From: Paul Cann
Sent: 21 November 2017 17:05
To: Planning.Responses
Subject: RE: Planning Consultation on AW/333/17/DOC

APPLICATION **AW/333/17/DOC**

Site Address: 90 Rose Green Road ALDWICK PO21 3EQ

Description of Works: Application for approval of details reserved by conditions imposed on planning ref AW/138/17/PL relating to conditions no 5 (site meeting), 6, 7, 8 (drainage), 9 (Contamination), 10 (Reptile mitigation details) 12 (materials & finishes) 13 (Landscaping) & 22 (External lighting)

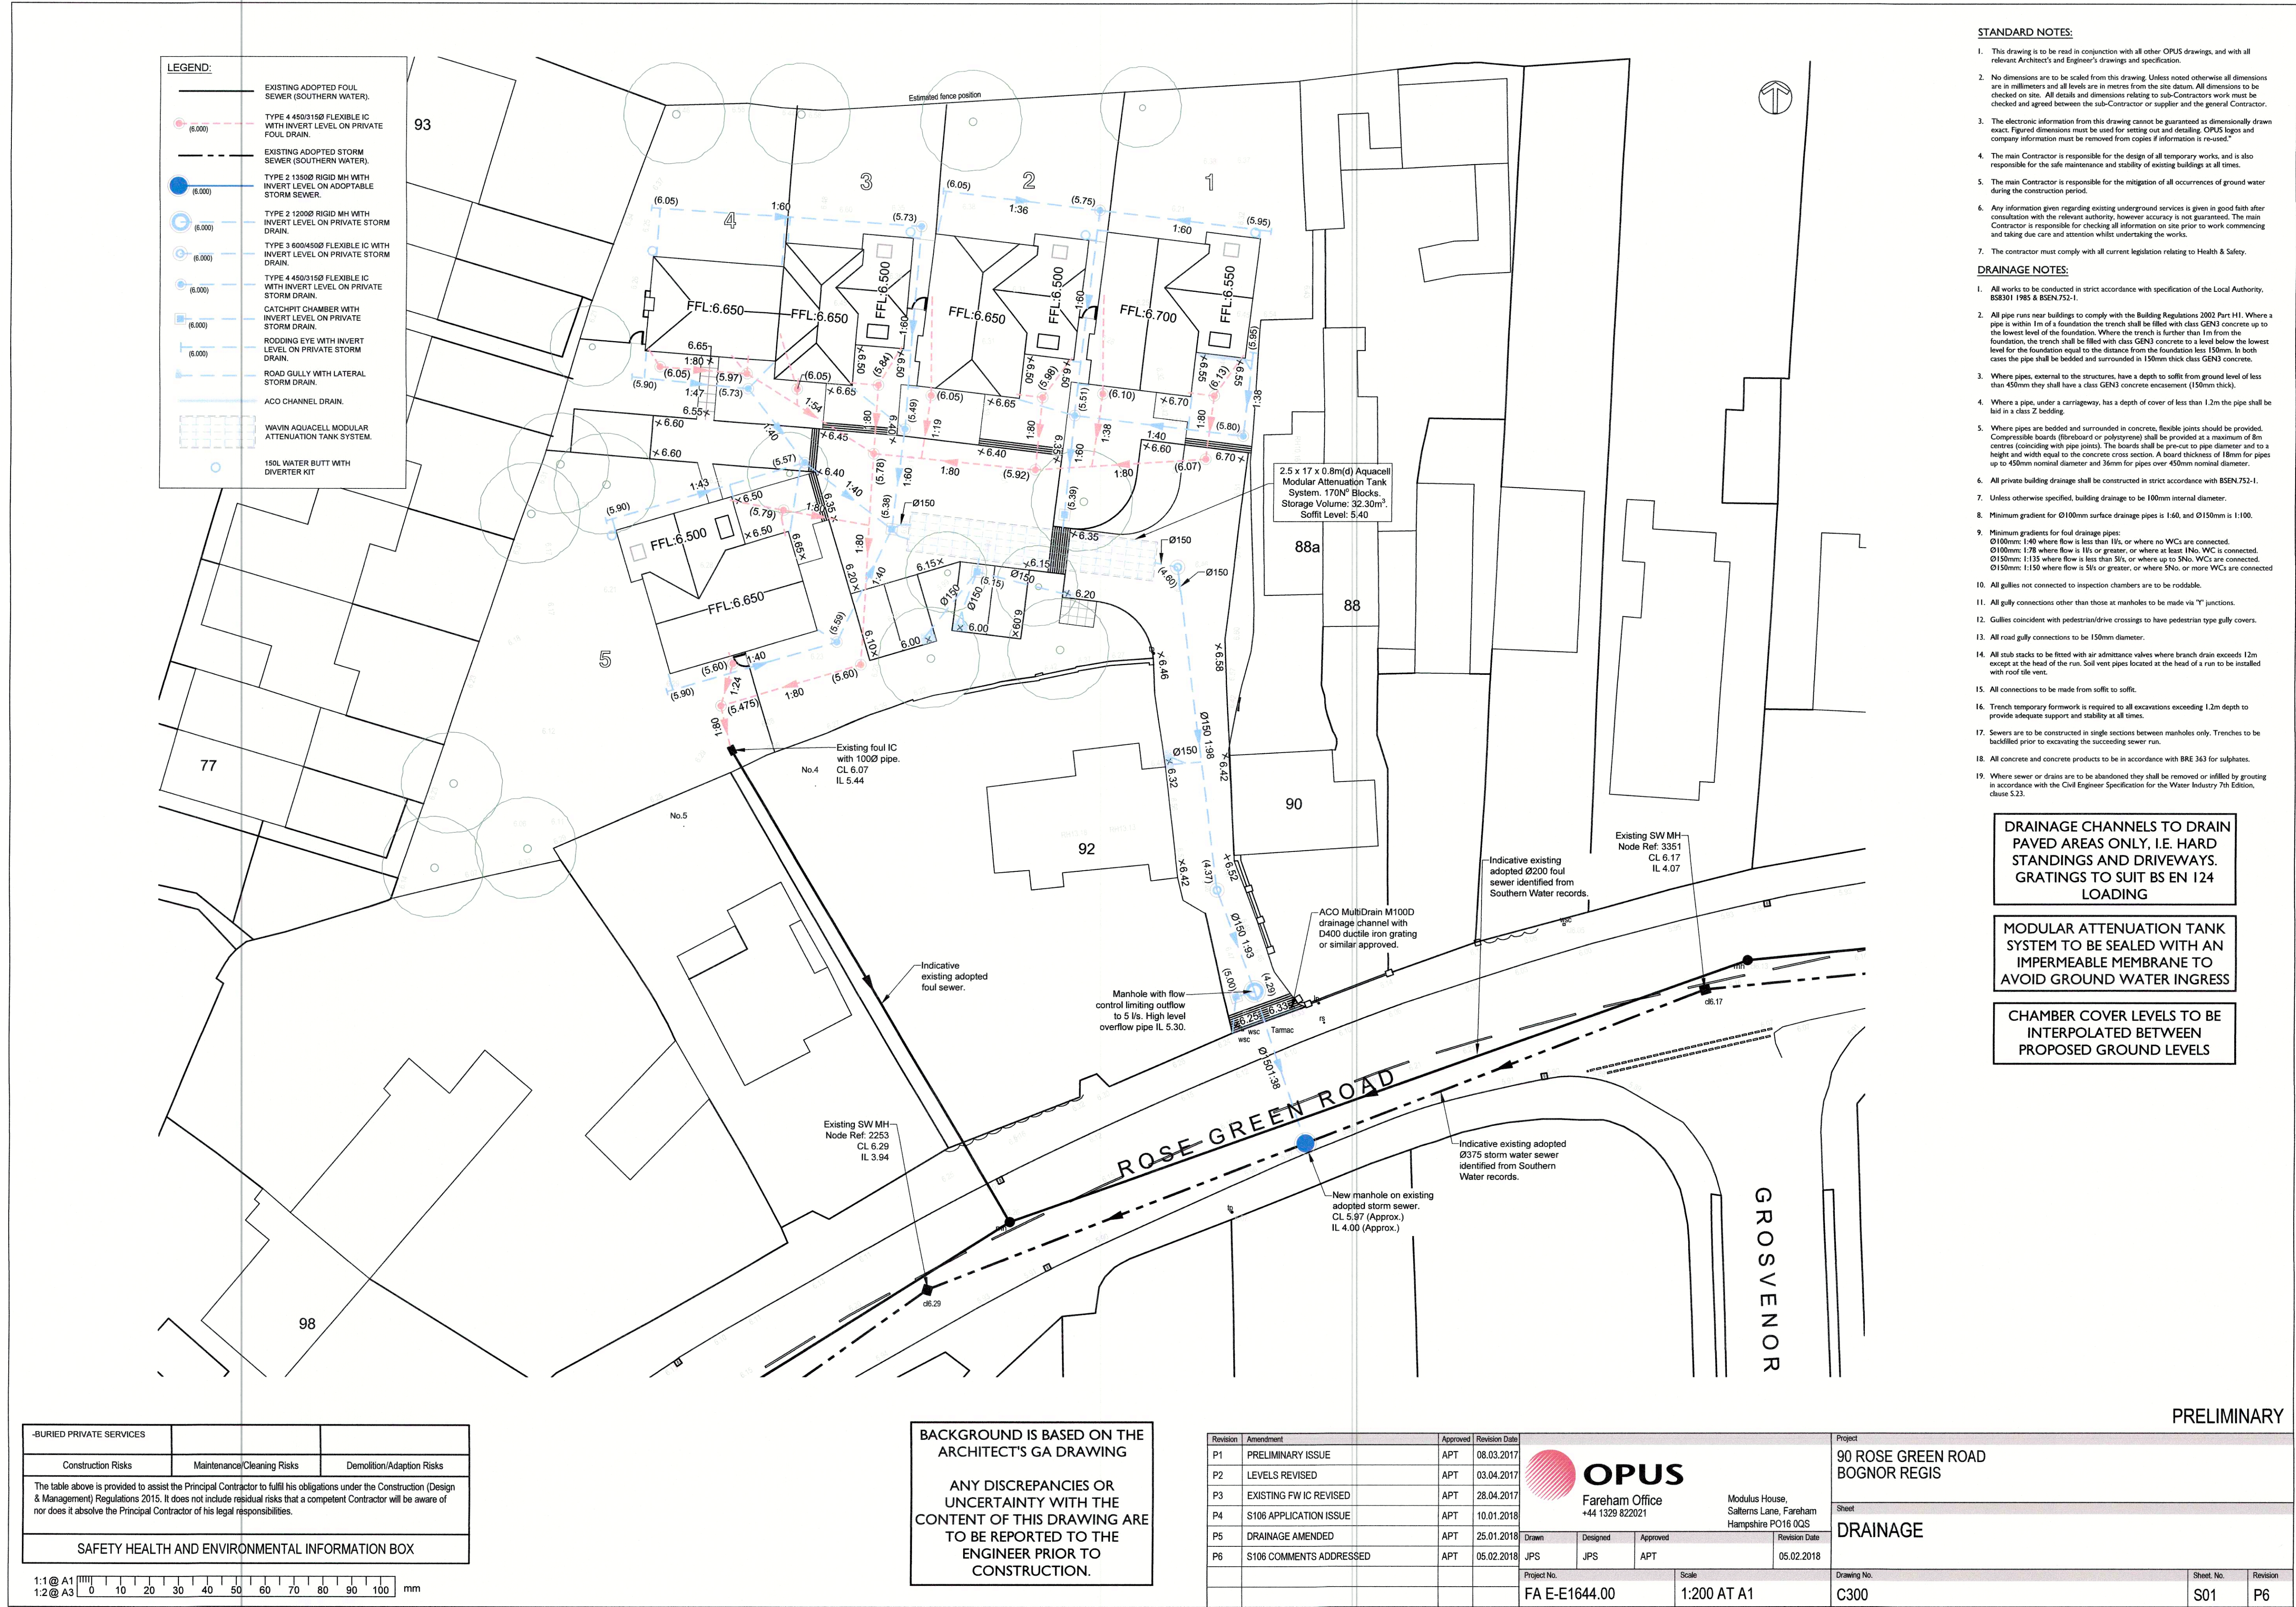
1. Drainage layout drawing needs to include all relevant cover levels, invert levels and pipe gradients. Silt traps are required where necessary (indicate locations).
2. Provide construction detail drawing for attenuation tanks, sump manholes, non-sump manholes, hydrobrake/flow control chamber, etc.
3. Is an emergency overflow being provided at the flow control chamber?
4. The hydraulic calculations need to include the pipe network/impervious areas.
5. Flooding is noted on pipe no. 51.000 – applicant needs to show how this water will be accommodated on the site without affecting property.
6. Provide a copy of Southern Waters approval (method and construction) for the proposed connection to the public surface water sewer, together with their confirmation that adequate capacity exists to serve the development.
